Grahame Gould

Lead Member of the Examining Authority
Five Estuaries Windfarm DCO
National Infrastructure Planning
Temple Quay House
2 The Square, Bristol
BS1 6PN

Our Ref 20048270
PINS Ref: EN010115
Date: 14 March 2025

Planning Act 2008**Application by Five Estuaries Offshore Wind Farm Limited for an order granting development consent for the Five Estuaries Offshore Wind Farm project.**

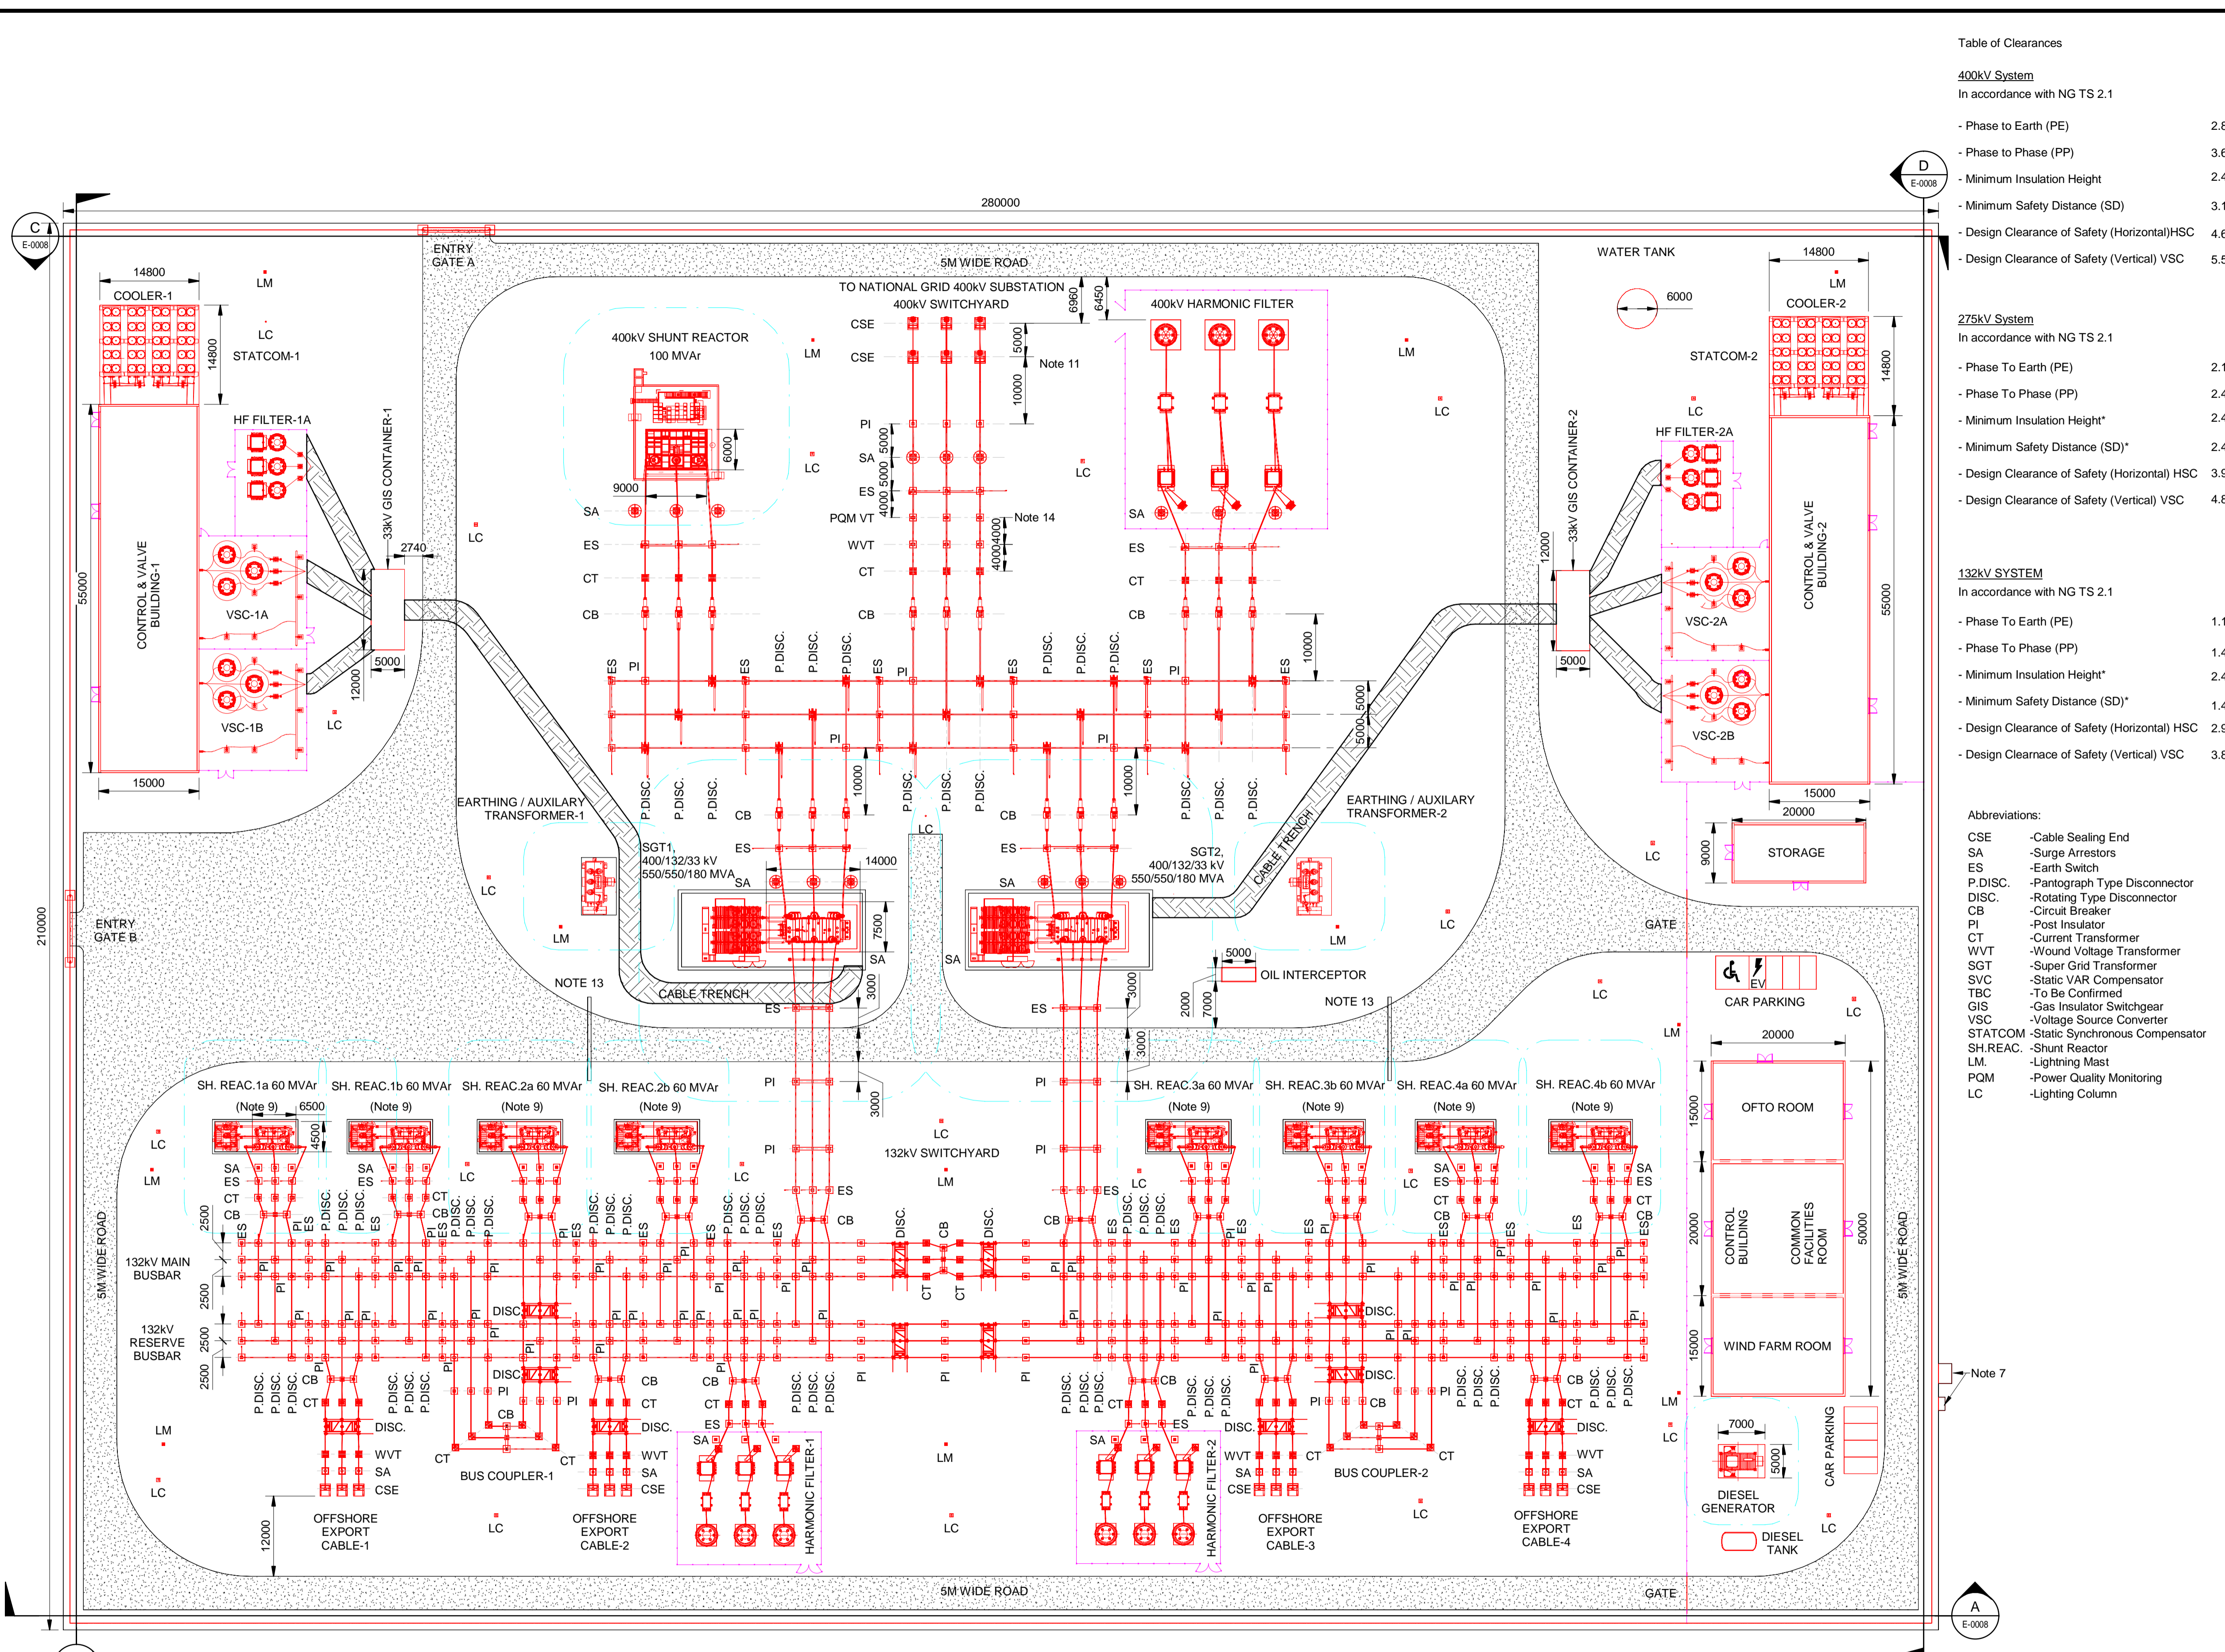
While ECC notes and welcomes the reference (para 2.3.7) to an external review of the Design Guide being carried out by an external body. We note that this would be a two-stage process, at present the initial phase is solely carried out by the Applicant’s internal Design Review Panel. In order to ensure that any external views are taken on broad and able to influence the development of the Design Guide, the Councils request that there should be external involvement on the Design Review Panel throughout the process as shown in

Figure 1 of the Onshore Substation Design Principles Document (REP8-019). At least a representative from the Councils should be part of the Design Review Panel.

Proposed wording addition to para 2.3.6

The Design Champion(s) will lead the Design Review Panel(s) which will review the guide in advance of consultation with statutory consultees and local residents. The Design Review Panel is intended to be **predominantly** an internal panel.
